## **OXFORDSHIRE COUNTY COUNCIL'S RESPONSE TO CONSULTATION ON THE FOLLOWING DEVELOPMENT PROPOSAL**

**Application no:** 21/01630/OUT

**Proposal:** Outline planning application for residential development (within Use Class C3), open space provision, access, drainage and all associated works and operations including but not limited to demolition, earthworks, and engineering operations, with the details of appearance, landscaping, layout and scale reserved for later determination

**Location:** Land at North West Bicester Home Farm, Lower Farm and SGR2 Caversfield

DRAWING TITLE  
**CONSTRUCTION ACCESS  
OVERVIEW PLAN**

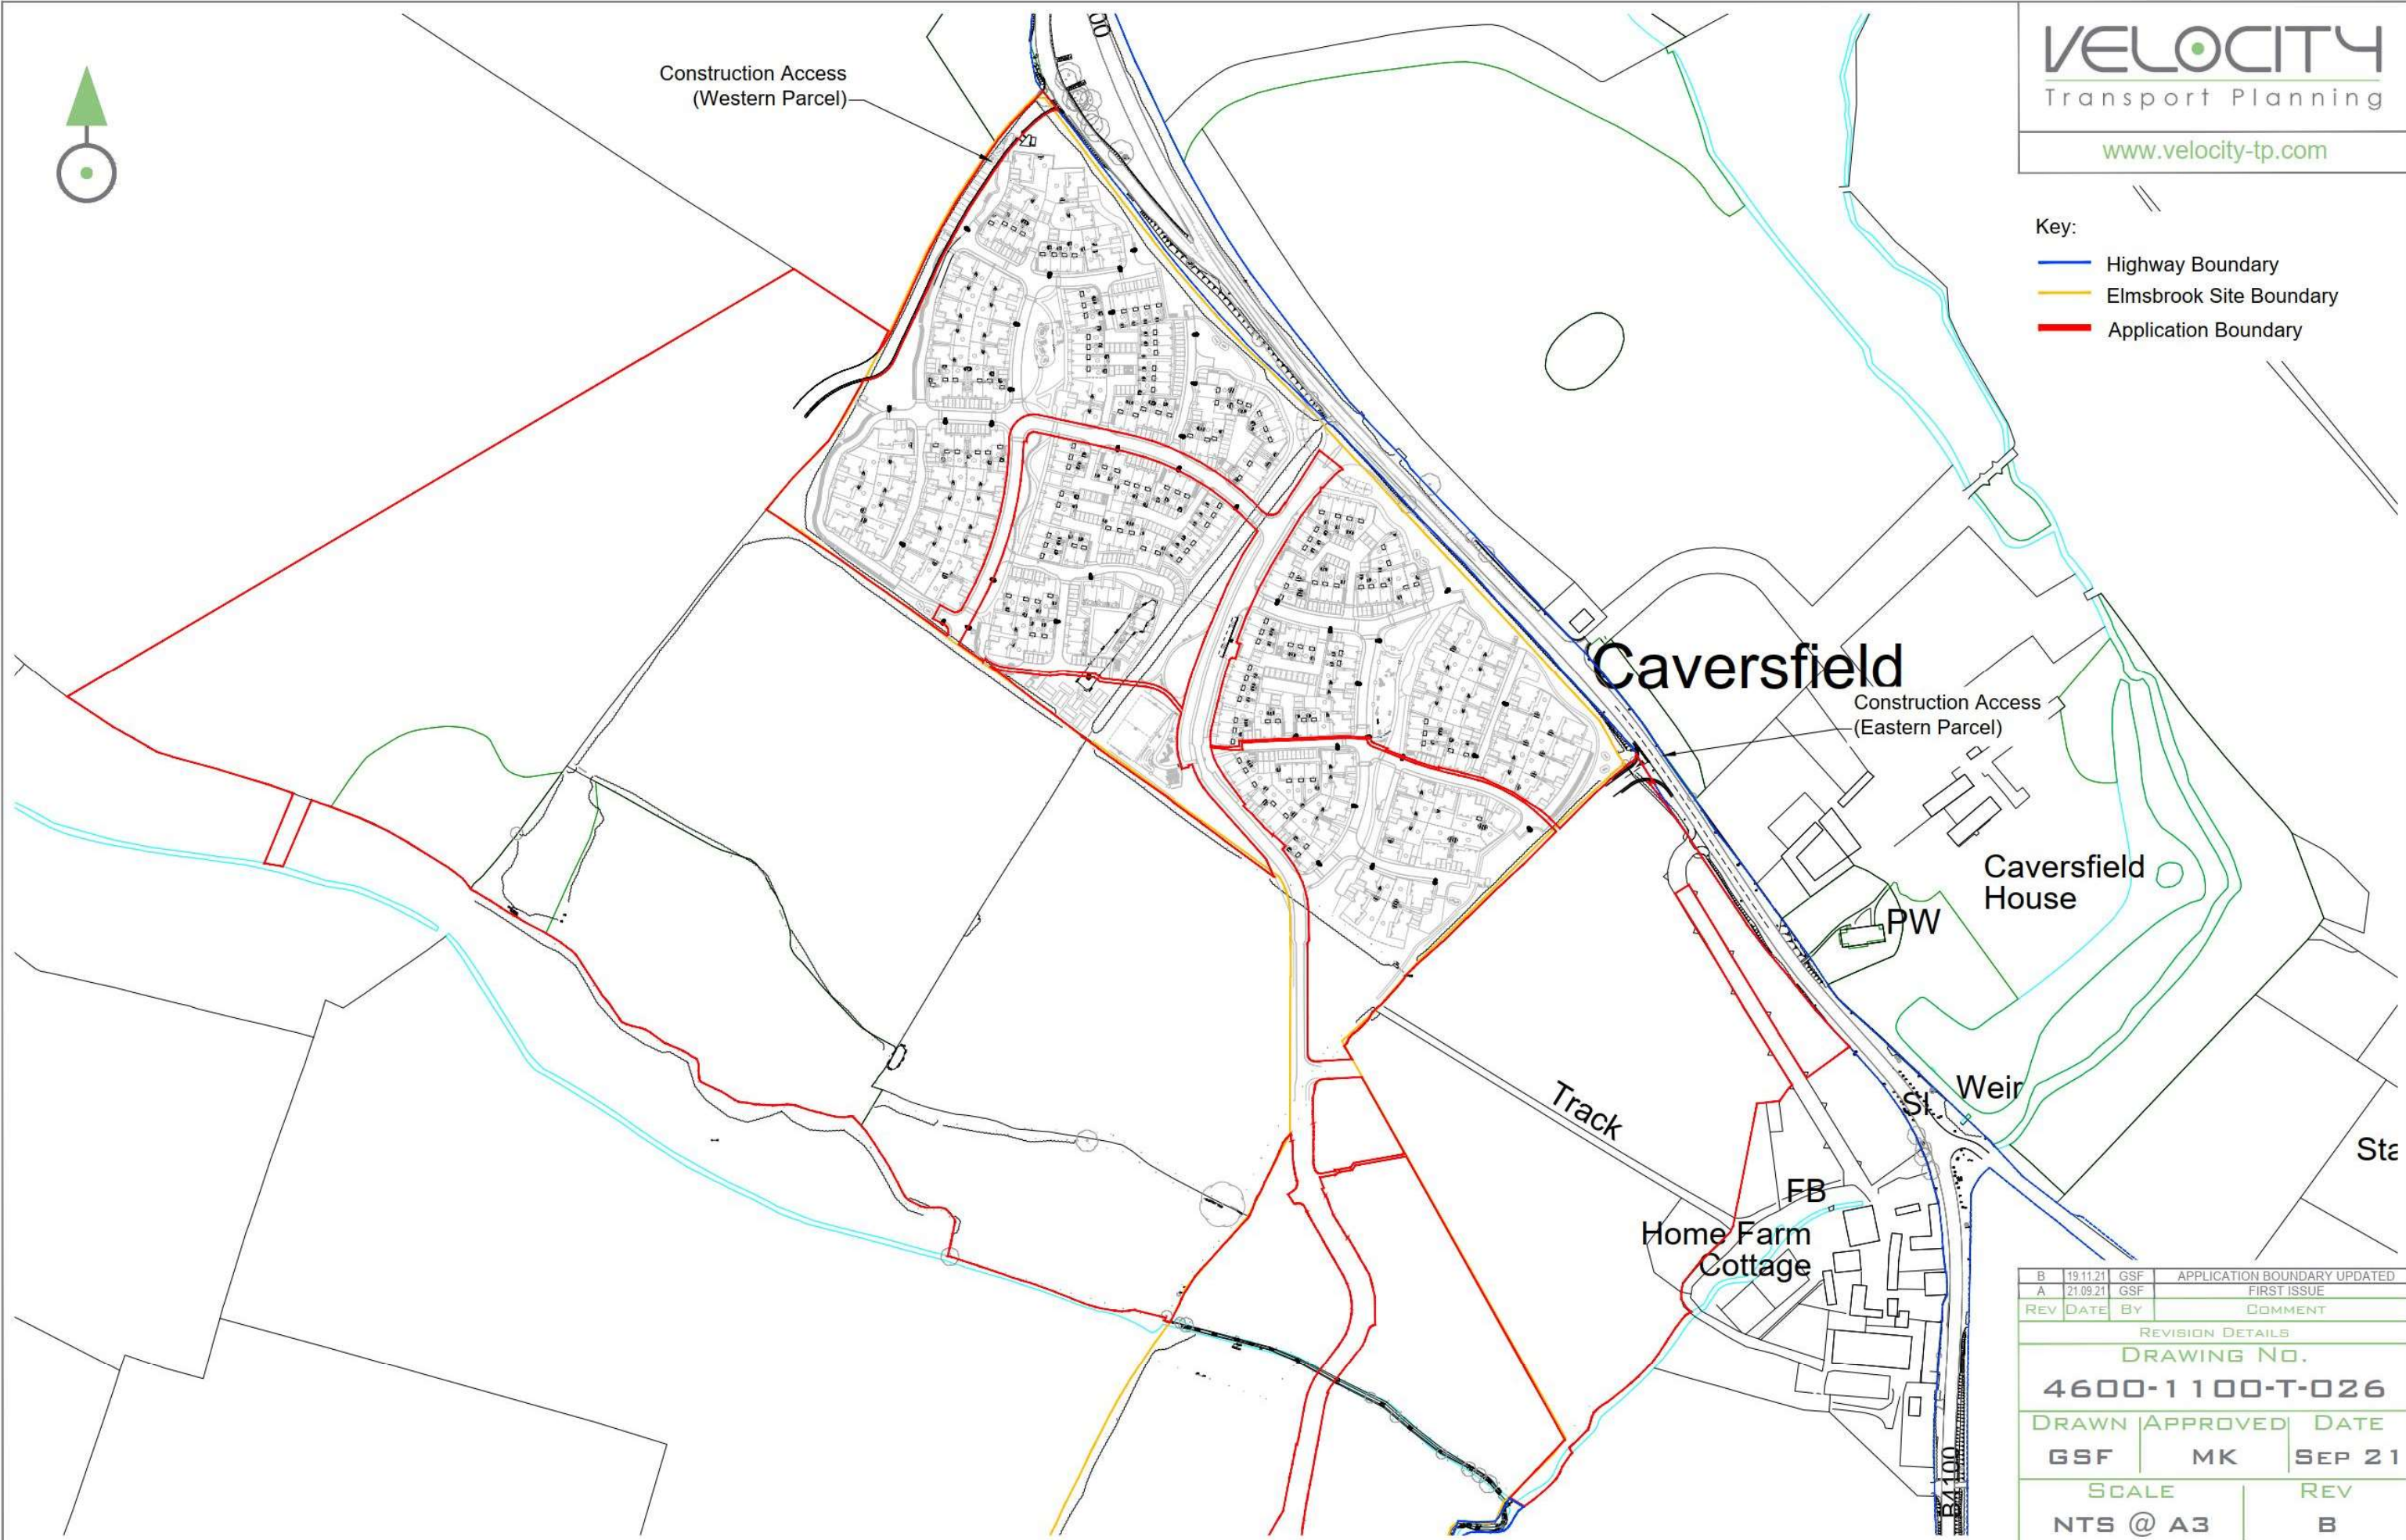
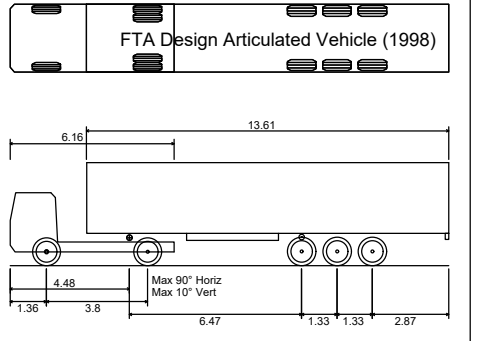
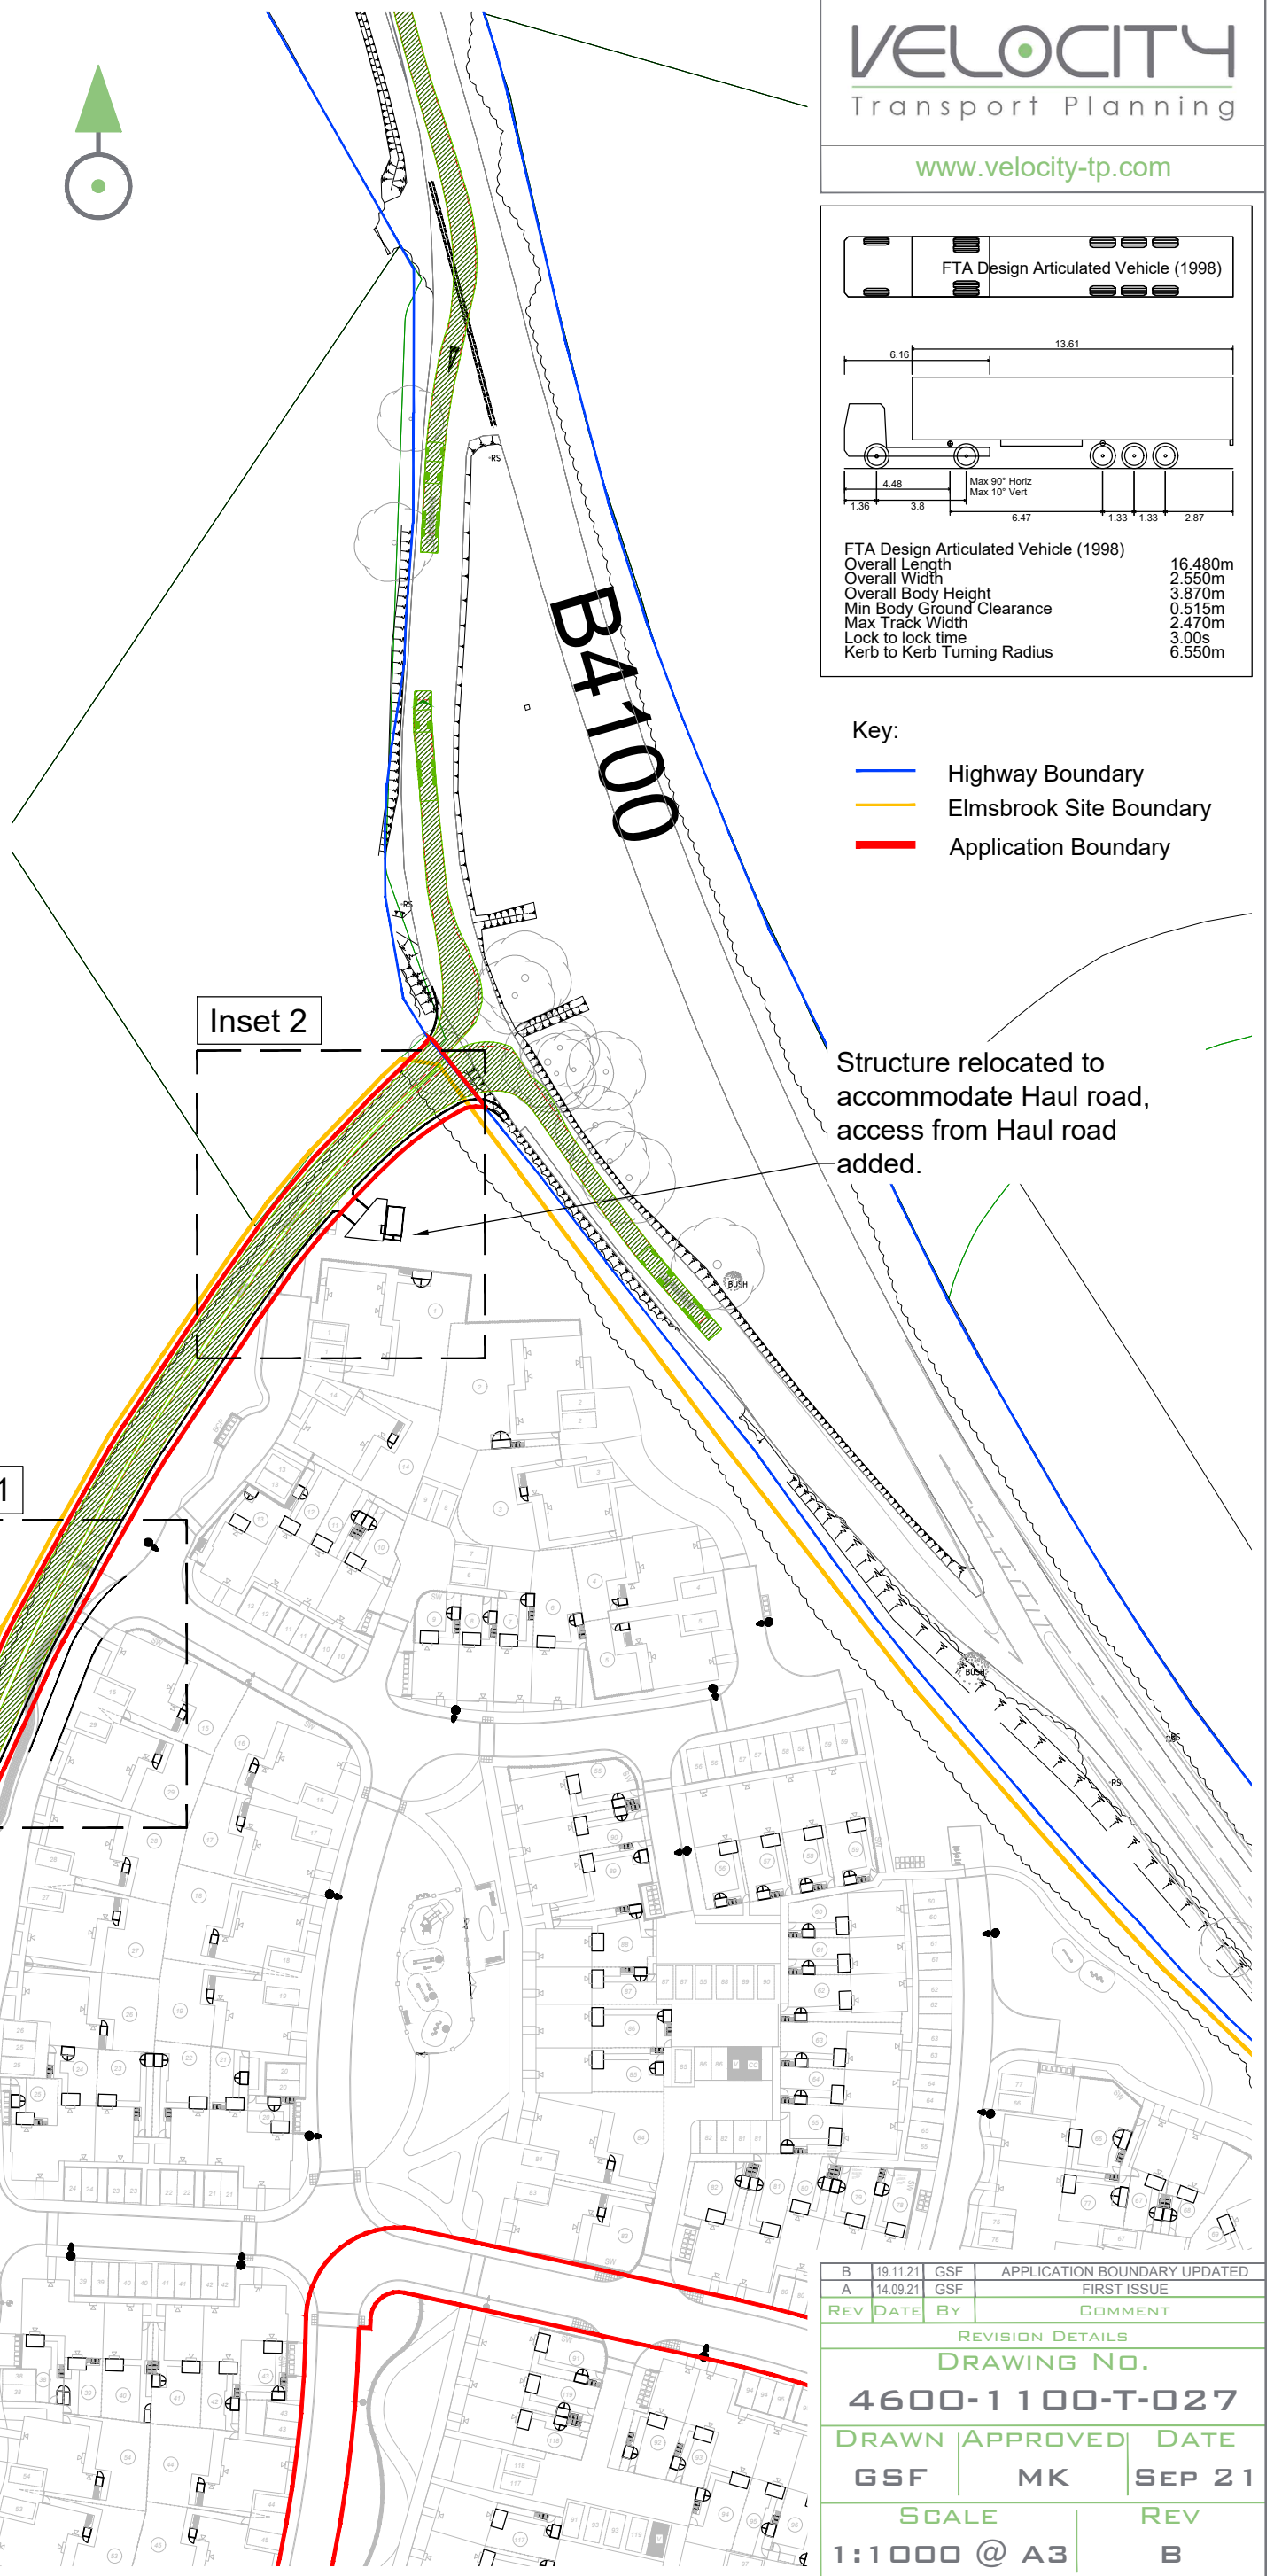
- A revised parameter plan has been submitted, removing the word 'potential' from the pedestrian and cycle connections to adjacent sites.
- Concern has been raised for the safety of pedestrians, especially from Elmsbrook, accessing the public footpath which leads southwest from the B4100 layby, immediately north of the proposed haul route.

- The updated site access arrangement drawings are acceptable subject to technical audit.
- The applicant agrees to points raised in relation to proposed construction access. An additional point has been raised regarding safe pedestrian access to the public footpath leading southwest from the layby, immediately north of the haul road. This will need to be considered in the design.

The development shall not commence on any phase until full details of construction accesses and haul routes serving that phase including position, layout, drainage, gates, signage and alterations to the adjacent highway including the B4100 layby have been submitted and approved in writing by the Local Planning Authority and the works have been completed in accordance with the approved details.

APPENDIX 4
DEVELOPMENT PARAMETER PLAN 3 – ACCESS AND MOVEMENT
(Amended)

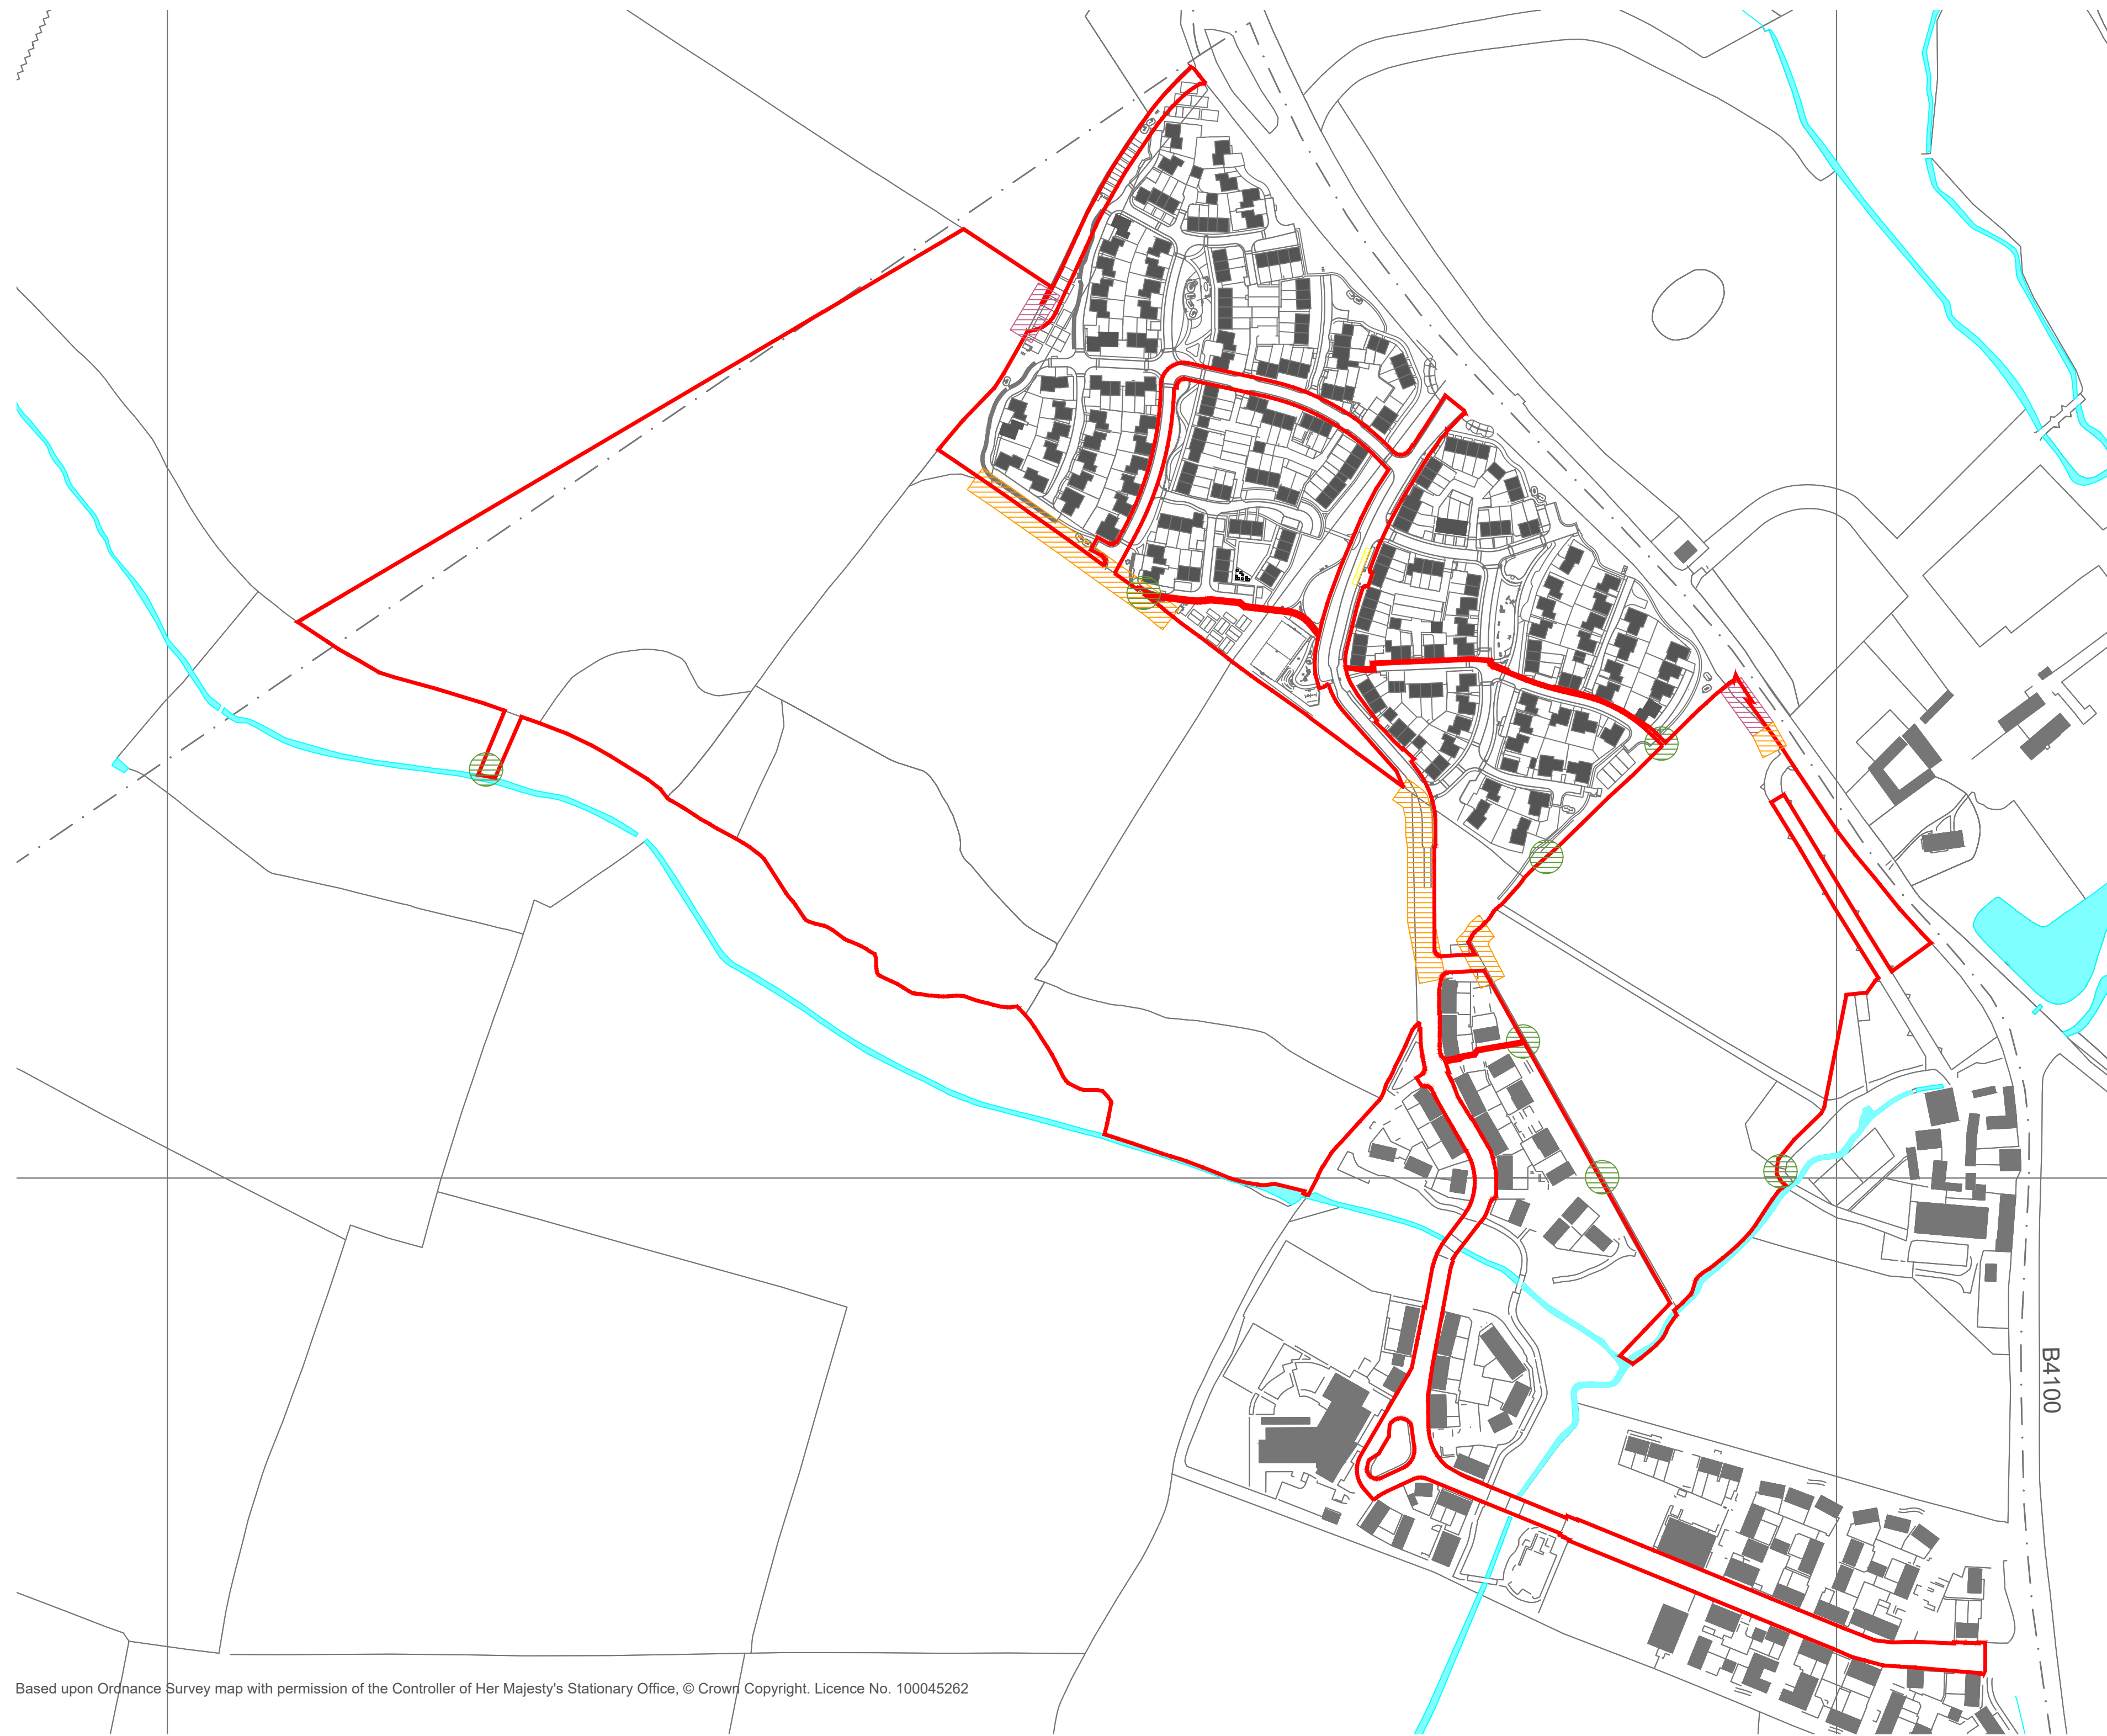
I note that the Access Parameter Plan has been updated to show pedestrian and cycle connection points to adjacent sites as 'Pedestrian and cycle connection – subject to adoption and/or future development proposals beyond the boundary'. I am satisfied with this because it has removed the word 'potential'. It is acknowledged that a connection can only be made into the adjacent site if permission is granted by the other party to allow access across the boundary or if this is achieved by adoption. We would require a clause in the S106 legal agreement requiring the connection to be made to the boundary and for access to be permitted across the boundary from the site.
